**Re: SSD-8996 - Loreto Normanhurst - 91-93 Pennant Hills Road and 6-12 Mount Pleasant Avenue, Normanhurst.**

I refer to the above development proposal and provide the following comments from Council.

TREE TO BE REMOVED

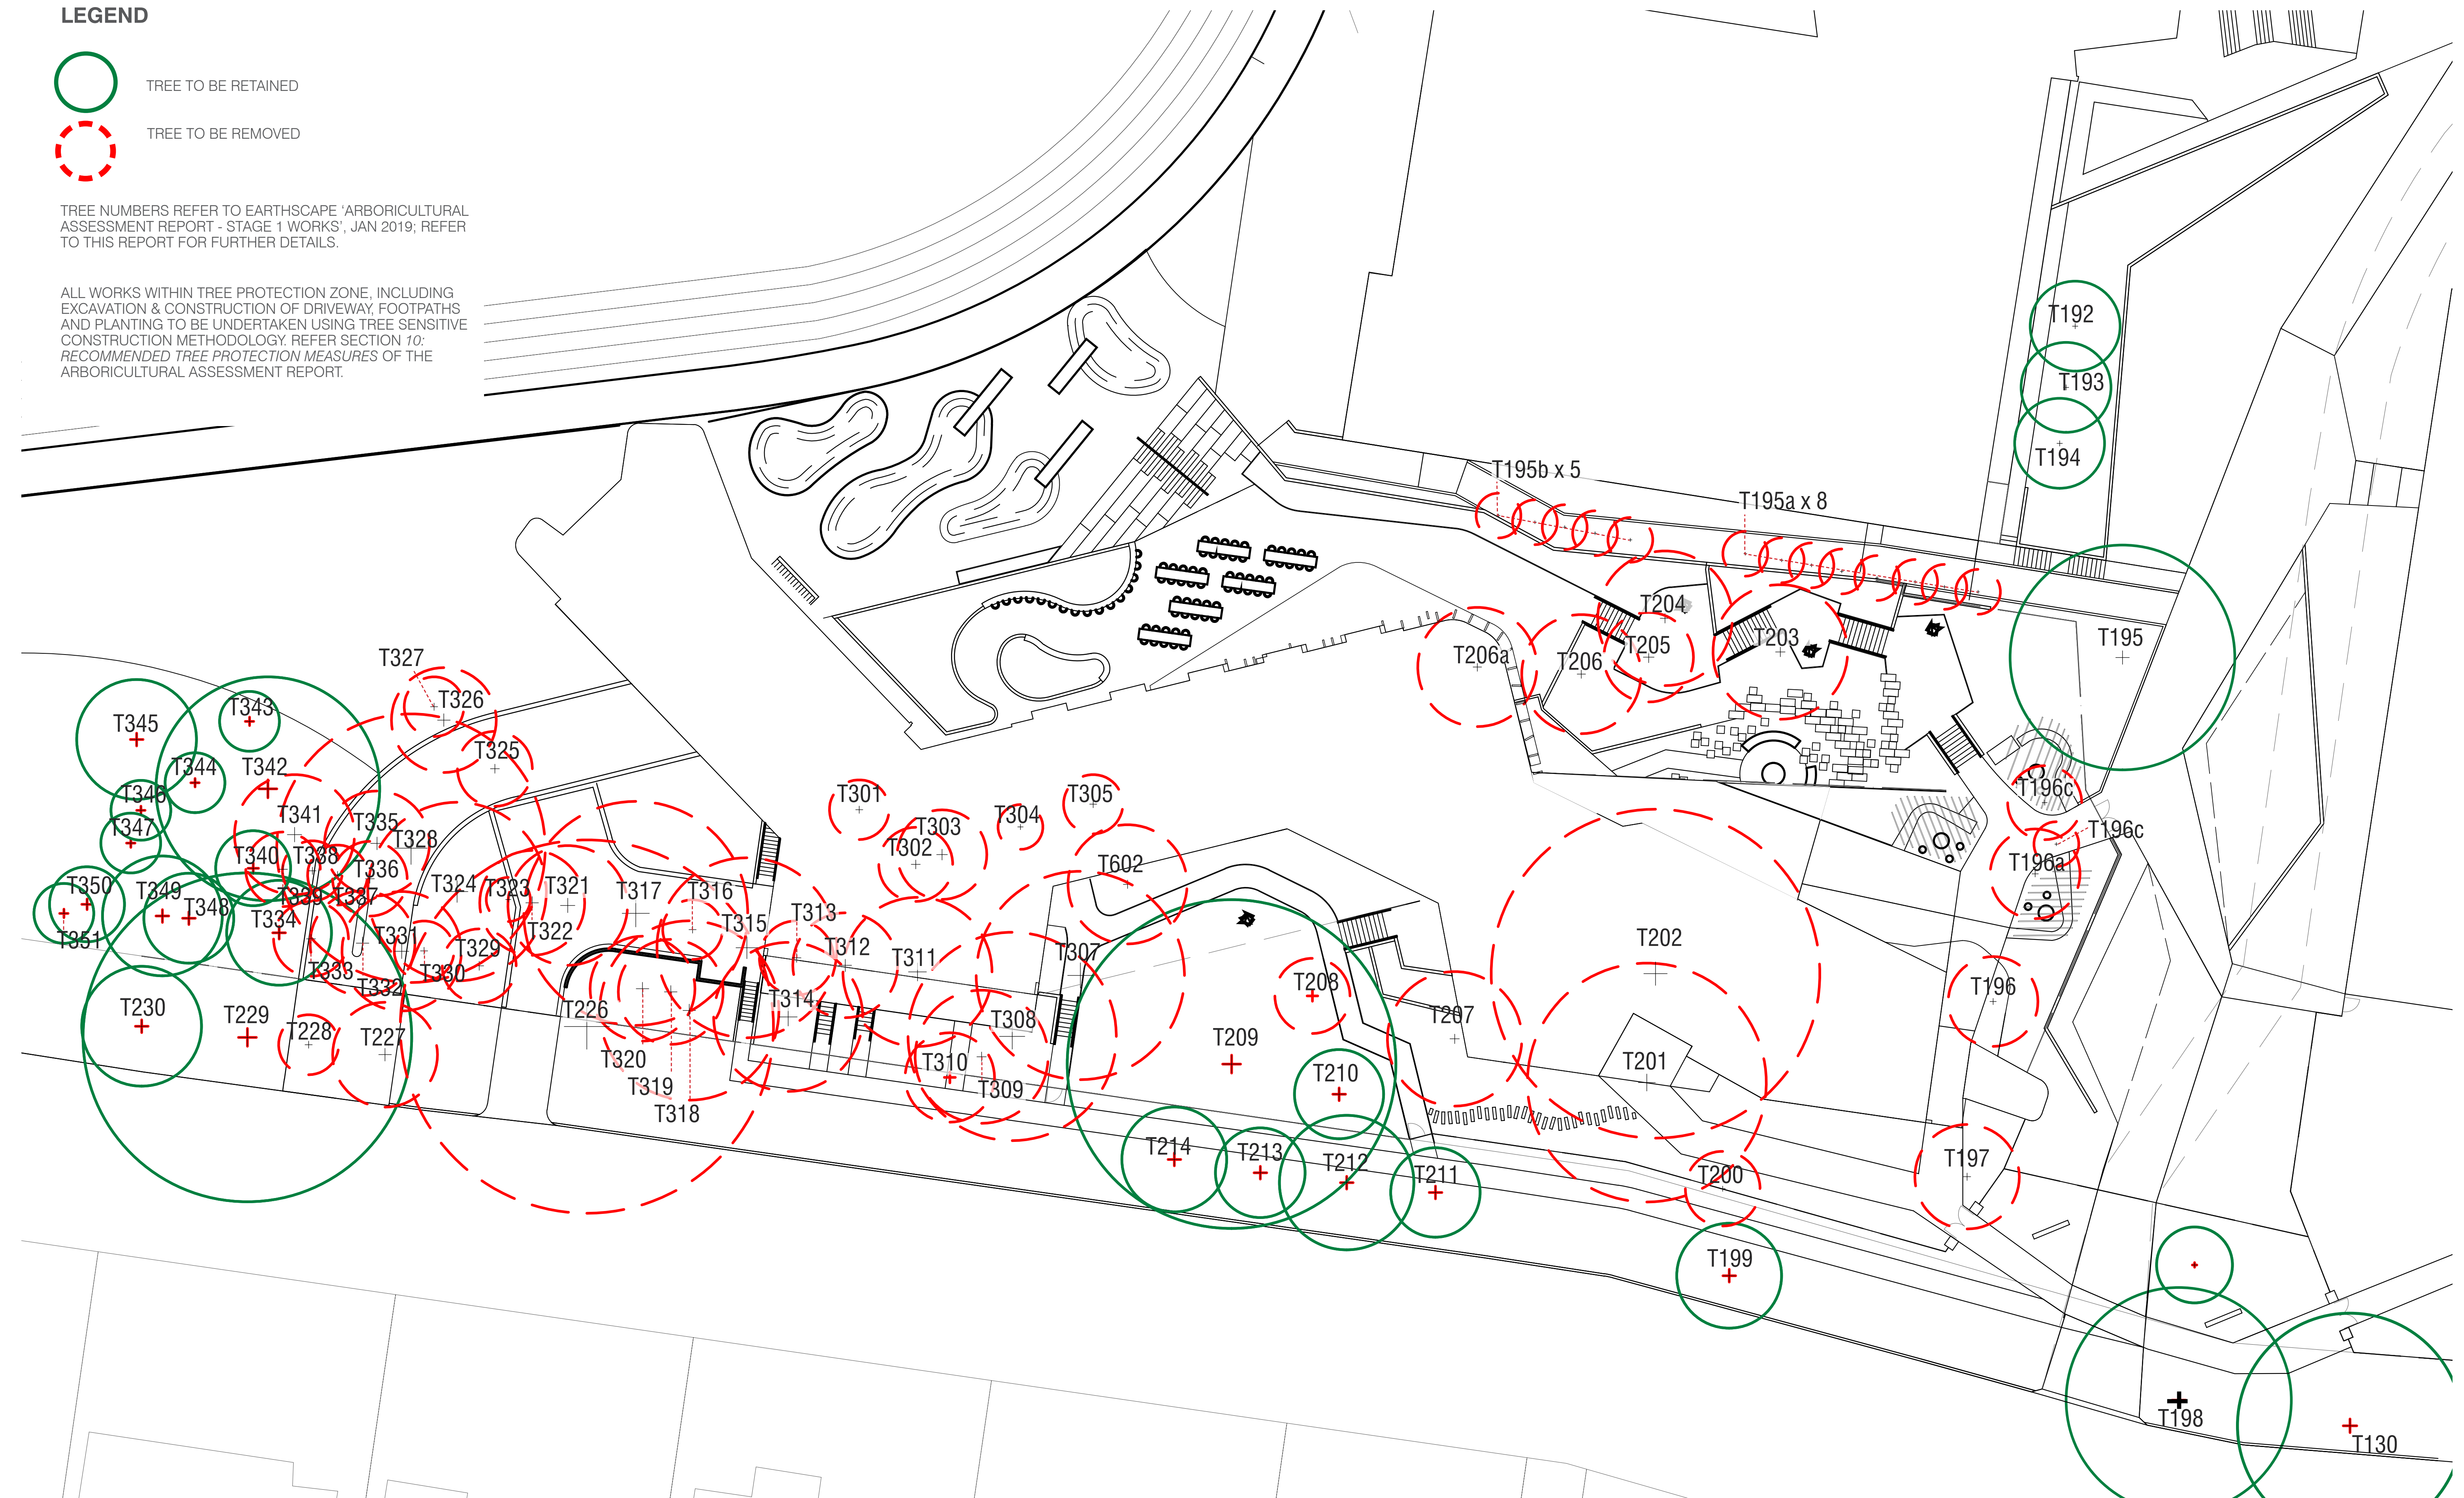
New landscaping located in the current primary school carpark, designed to allow for outdoor assembly of the whole school population.	No heritage concerns raised with the circa 1990s primary school car park landscaping.
Removal and replacement of approximately 50 trees of varying significance.	Tree removal should be limited wherever possible and replacement of trees removed is supported. No significant trees should be removed, and the heritage listed grounds as listed on the heritage inventory sheet for the grounds should be retained. Comment from Council’s Tree Management team should be sought.
Augmentation of connection of services and utilities infrastructure	Should occur only in accordance with the CMP policy for services.

Council raises concerns with the loss of high retention value trees on the site.
